From: Andrew Hedger [REDACTED]
Sent: 02 February 2016 09:51
To: Richard Temple
Cc: Tim Pearce; Rachel Bird
Subject: RE: Barnham Court Solar Panel Heights

From: Andrew Hedger [REDACTED]
Sent: 28 January 2016 17:17
To: Richard Temple
Cc: Tim Pearce; Rachel Bird
Subject: Barnham Court Solar Panel Heights

Further to our telephone conversation on Tuesday, the applicant has confirmed that it is possible to allow the trailing edge to be brought up to 1.3m with the top height remaining at 2.5m. This involves a change in the number of panels per array and a slight change in the angle of the panels.

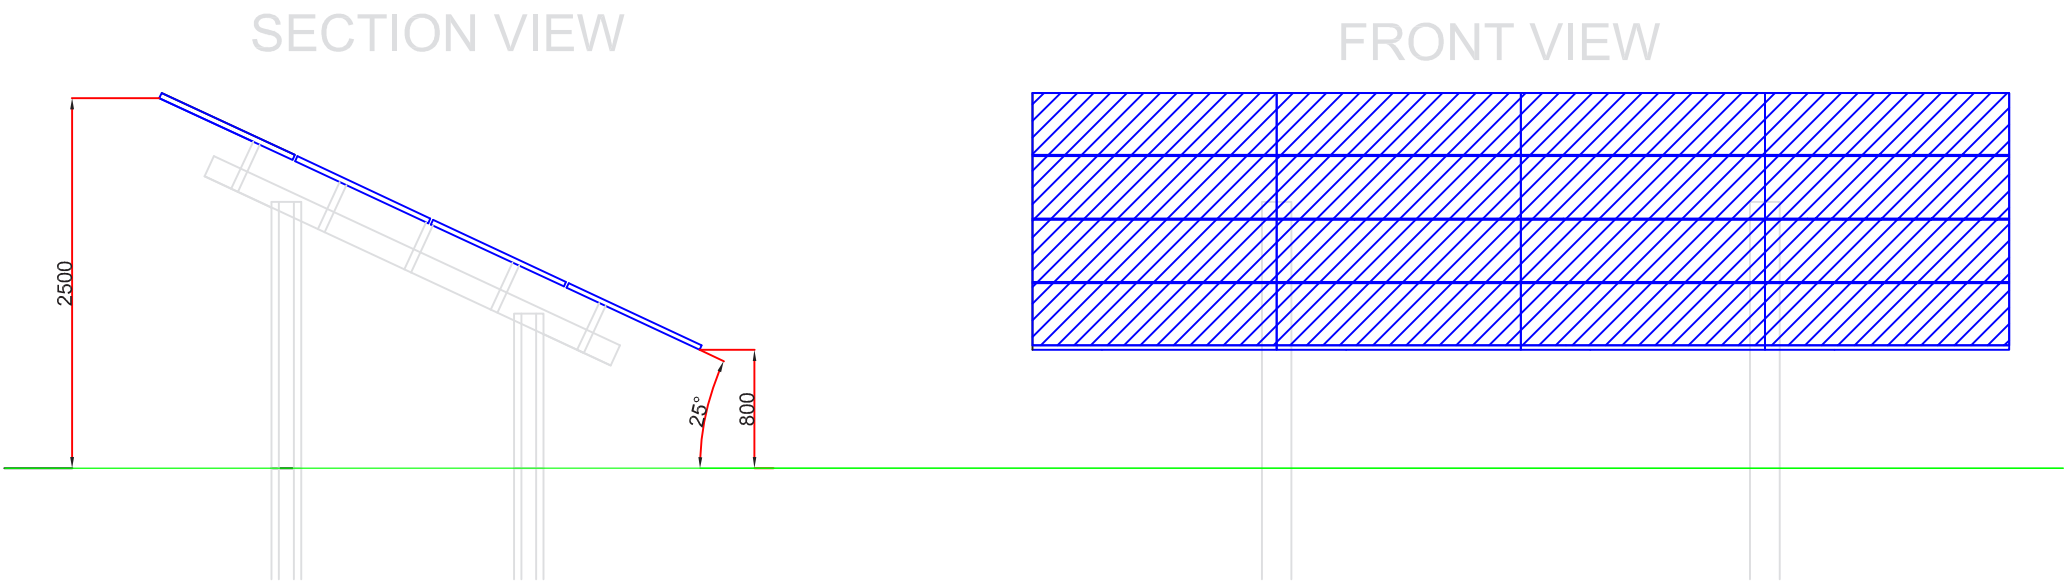
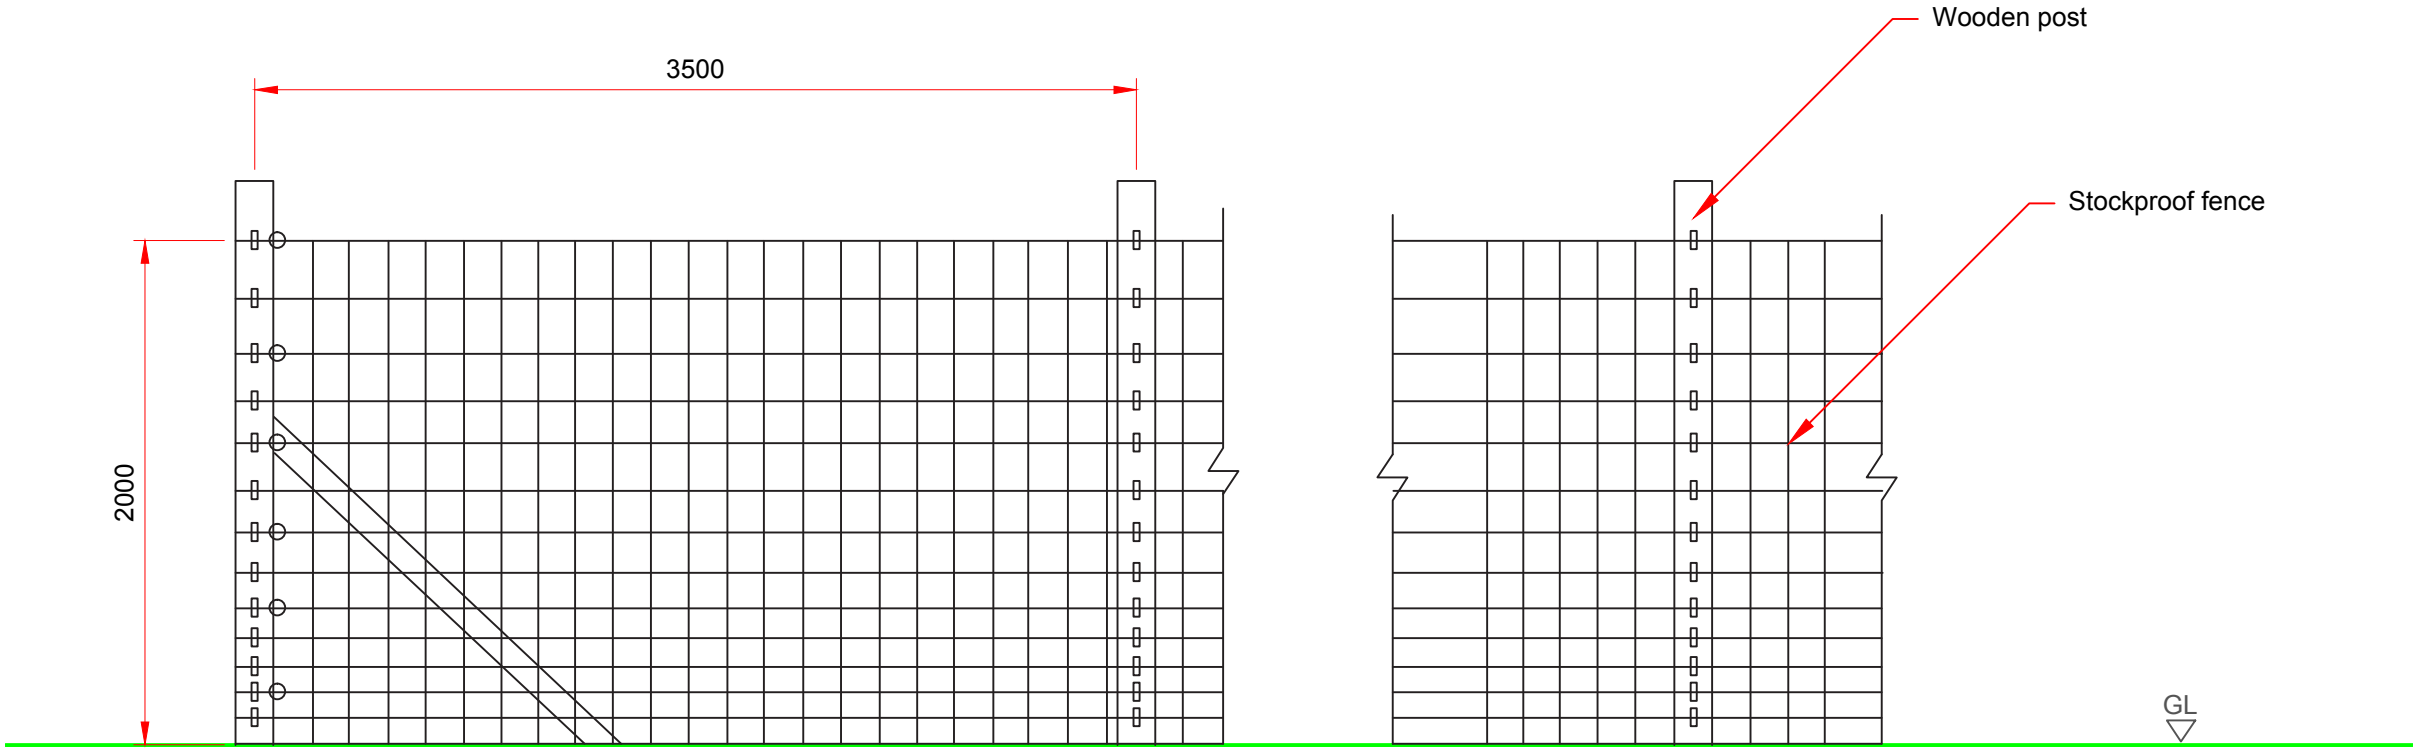
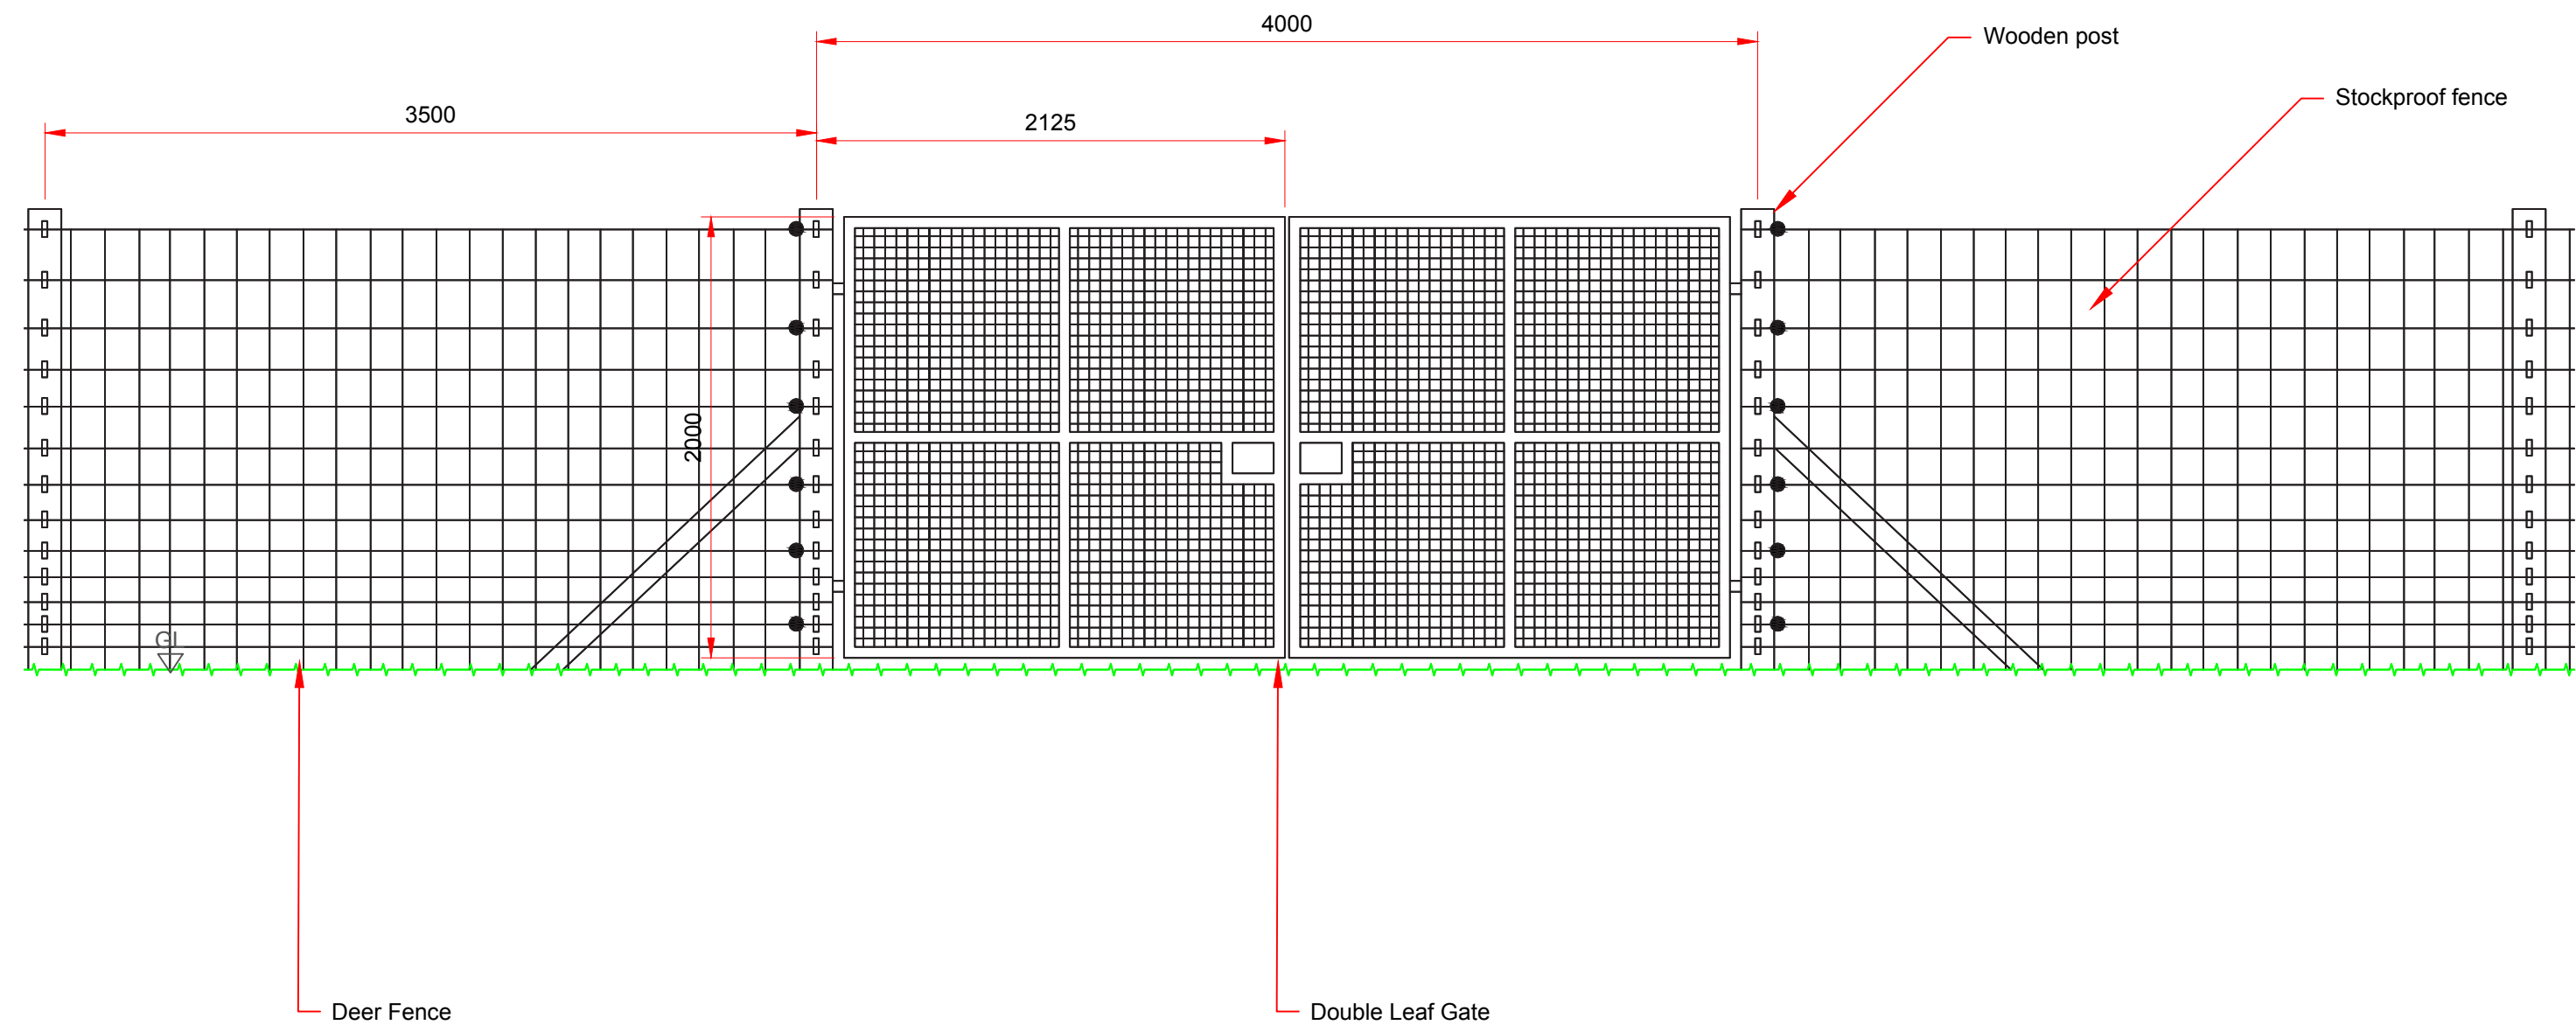
'Instead of 4 (@300) in landscape we will have to do 3 in landscape at 23.50 degrees, with 1.3m at the trailing edge and 2.5m at the leading edge.'
